**Crown Sydney Hotel Resort, Barangaroo (SSD_6957) and
Stage 1C Remediation and Earthworks, Barangaroo (SSD6956)
Response to exhibition of Environmental Impact Statements**

Crown Sydney Hotel Resort, Barangaroo (SSD_6957) and Response to exhibition of EIS Detailed comments by DPI Water

Stage 1C Remediation and Earthworks, Barangaroo (SSD6956) Response to exhibition of EIS Detailed comments by DPI Water

Title: Permanent Retaining Wall Plan
Stage 1C Remediation & Earthworks
Subject To This Application

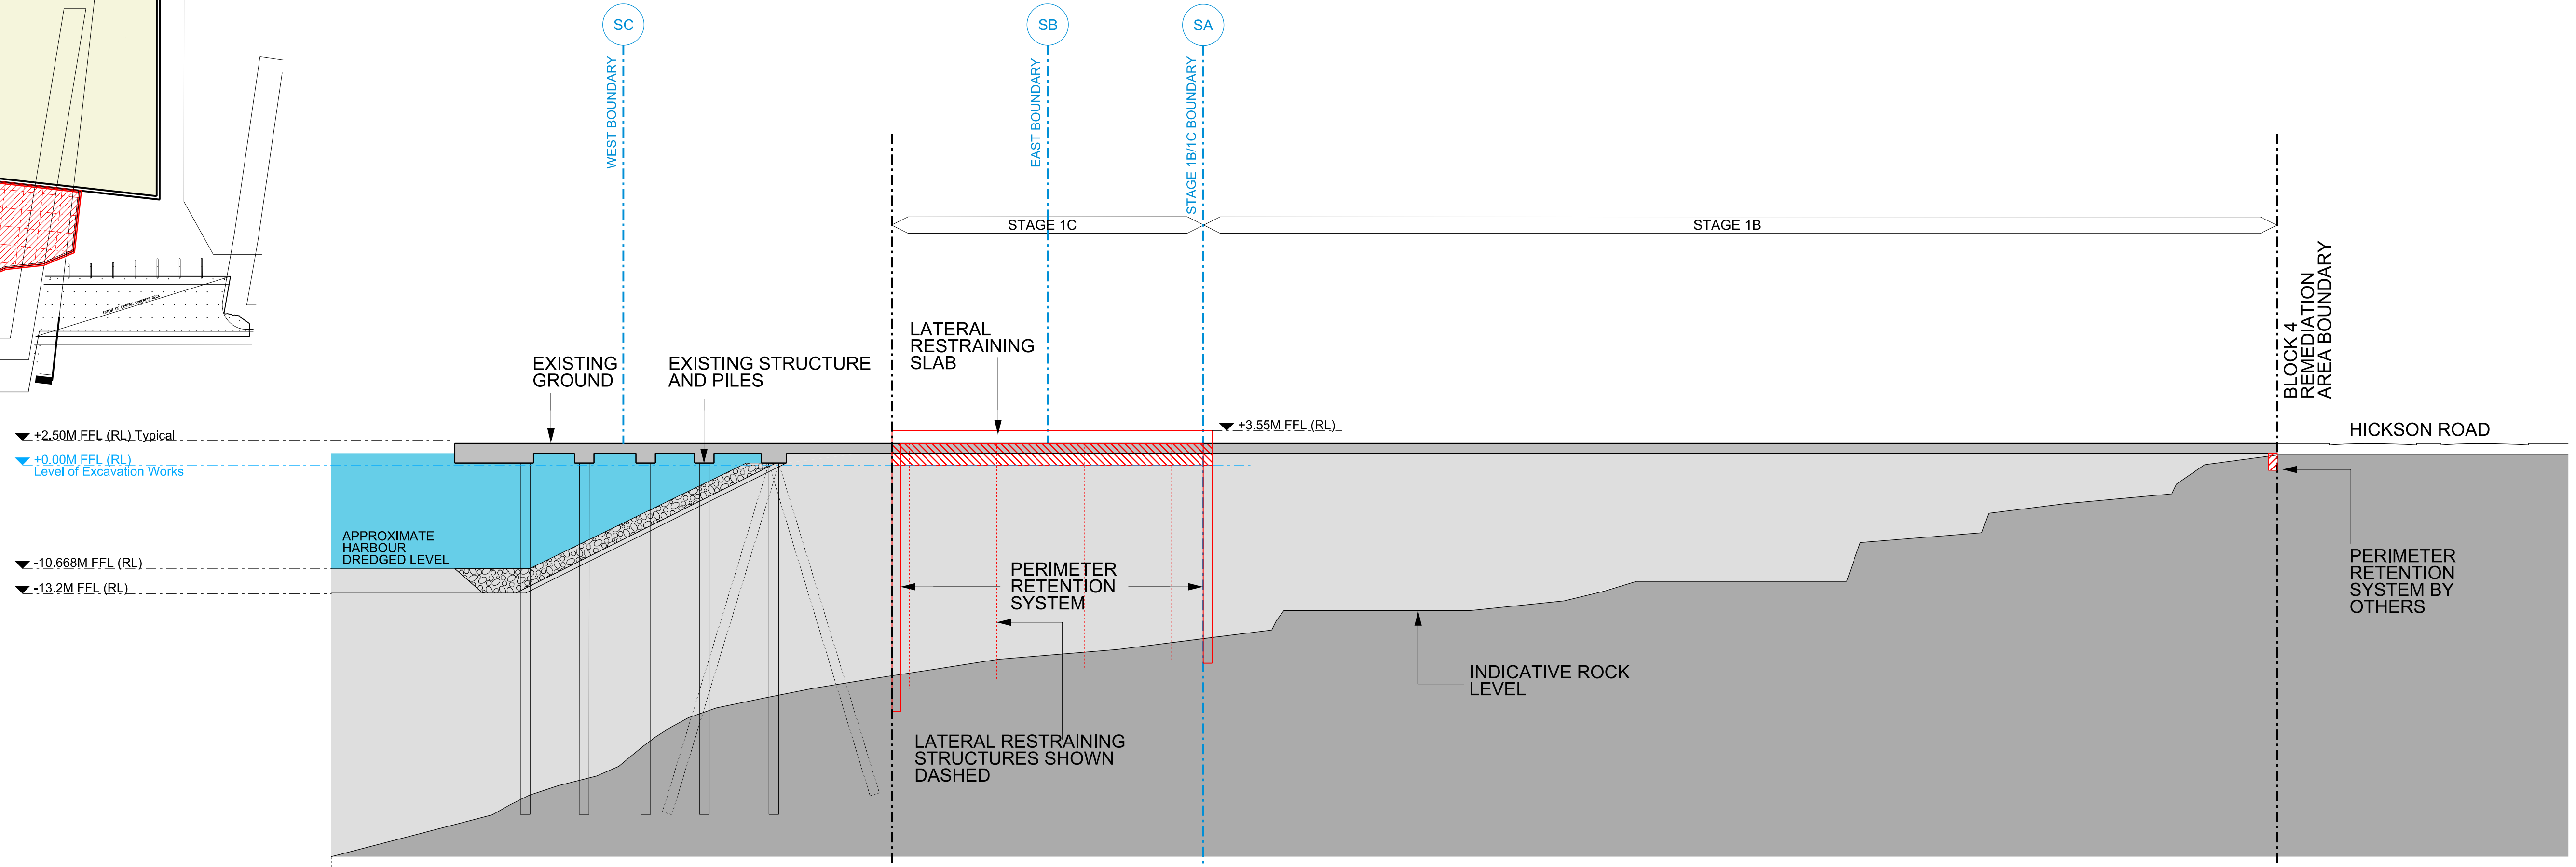
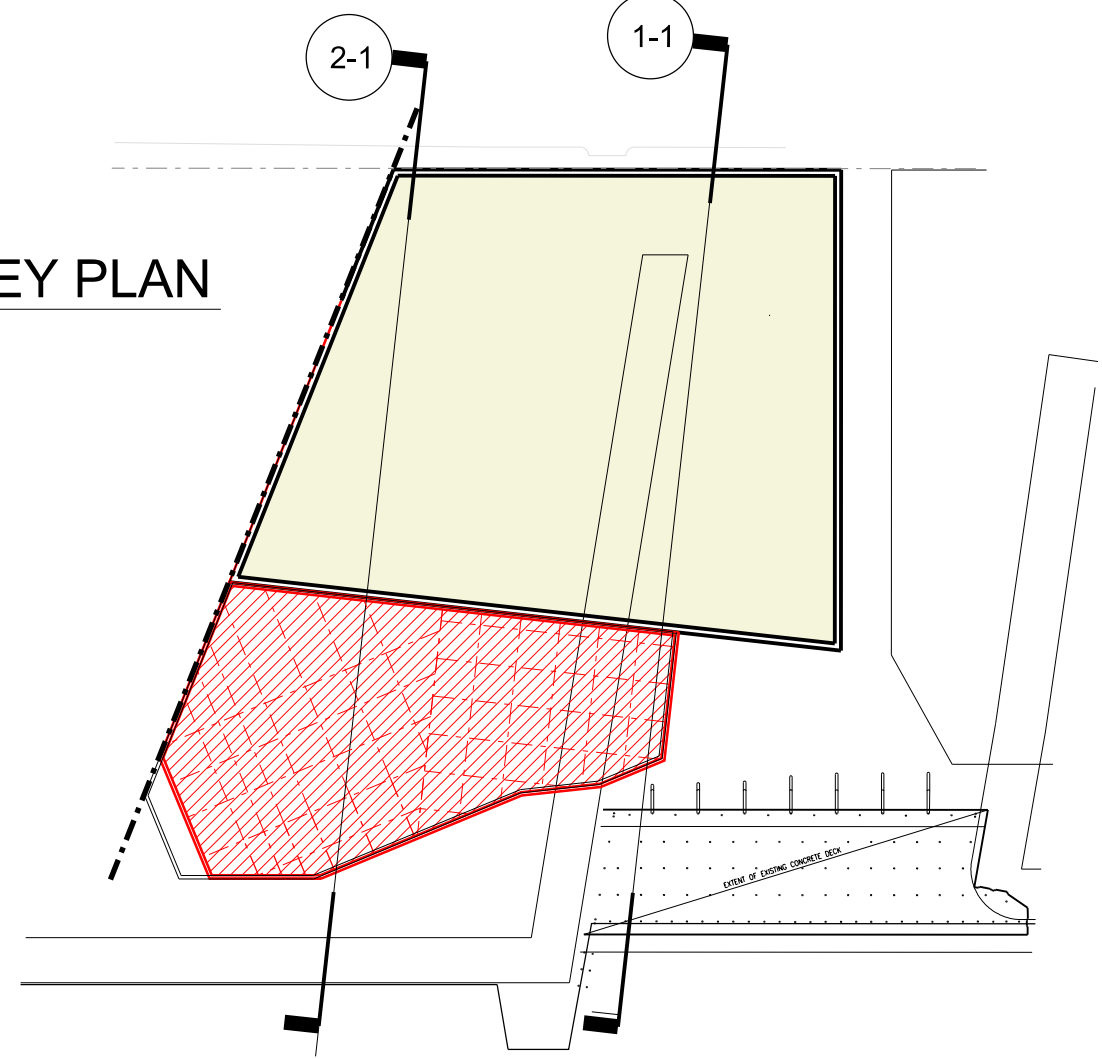
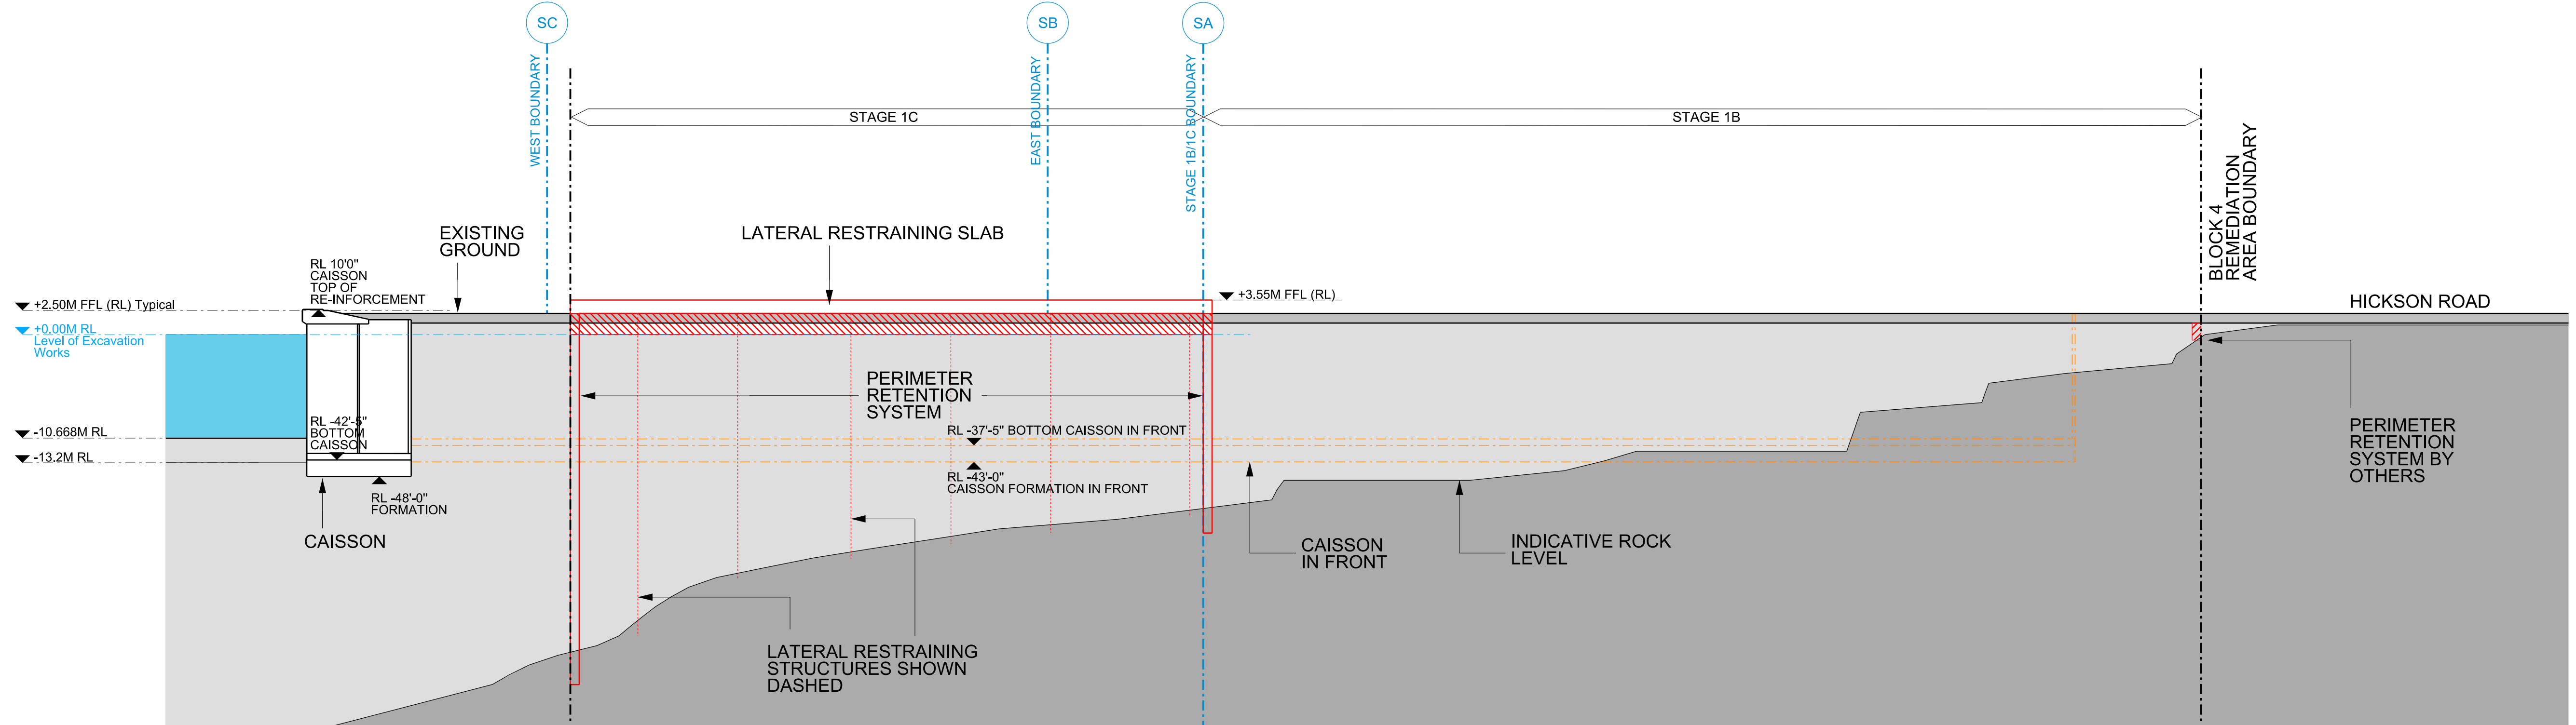
The design of the groundwater retention system has not been considered here (or sighted) and few details are known about it, however it has been described as minimum 800 mm wide (Section 4.3 RAP) and socketed into weathered rock and extending around the perimeter of the approved basement footprint. The system will be designed to prevent all groundwater migration from up-gradient sources into the basement area.

It can be anticipated that some small amount of mounding along the eastern boundary may be possible and this matter will need to be addressed by the design, probably by appropriate drainage around the system.

RAP Section 7.2.2 discusses the matter of ongoing seepage through the groundwater retention wall system and its association with future basement usage. Although the report discloses planning hydraulic conductivity values and seepage criteria as a maximum 0.75 L/min across the whole basement wall area, this value is not fully documented spatially (ie if the total area has been considered, or, if the rate is per lineal metre of perimeter) and does not seem to include floor seepage. Further the effect of seaward-facing construction and effects of saline water do not appear to have been separated out from landward-facing construction and fresh groundwater seepage. This matter needs to be clarified.

There is a need to ensure that the groundwater retention wall system does not induce excessive mounding which might then impact on neighbouring development or the community, and the potential to flood to the east should be also assessed and eliminated. When groundwater flows are interrupted by the retention system the flow dynamics and setting will change; for example, tidal influence on up-gradient flows will be entirely eliminated, or almost so; and saline mixing will cease. Provision for fresh groundwater drainage around the structure should be made.

- c. Reporting required with this plan is required under the relevant broader reporting framework under any development consent.
2. The potential groundwater take as seepage through the groundwater retention wall has to be clarified. The seepage rate needs to be tied to the area of wall and floor beneath the permanent saturated zone and that level to which the watertable may rise especially in response to mounding induced by the proposed construction. This volume may require on-going licensing, and the Proponent needs to liaise with DPI Water in this regard.
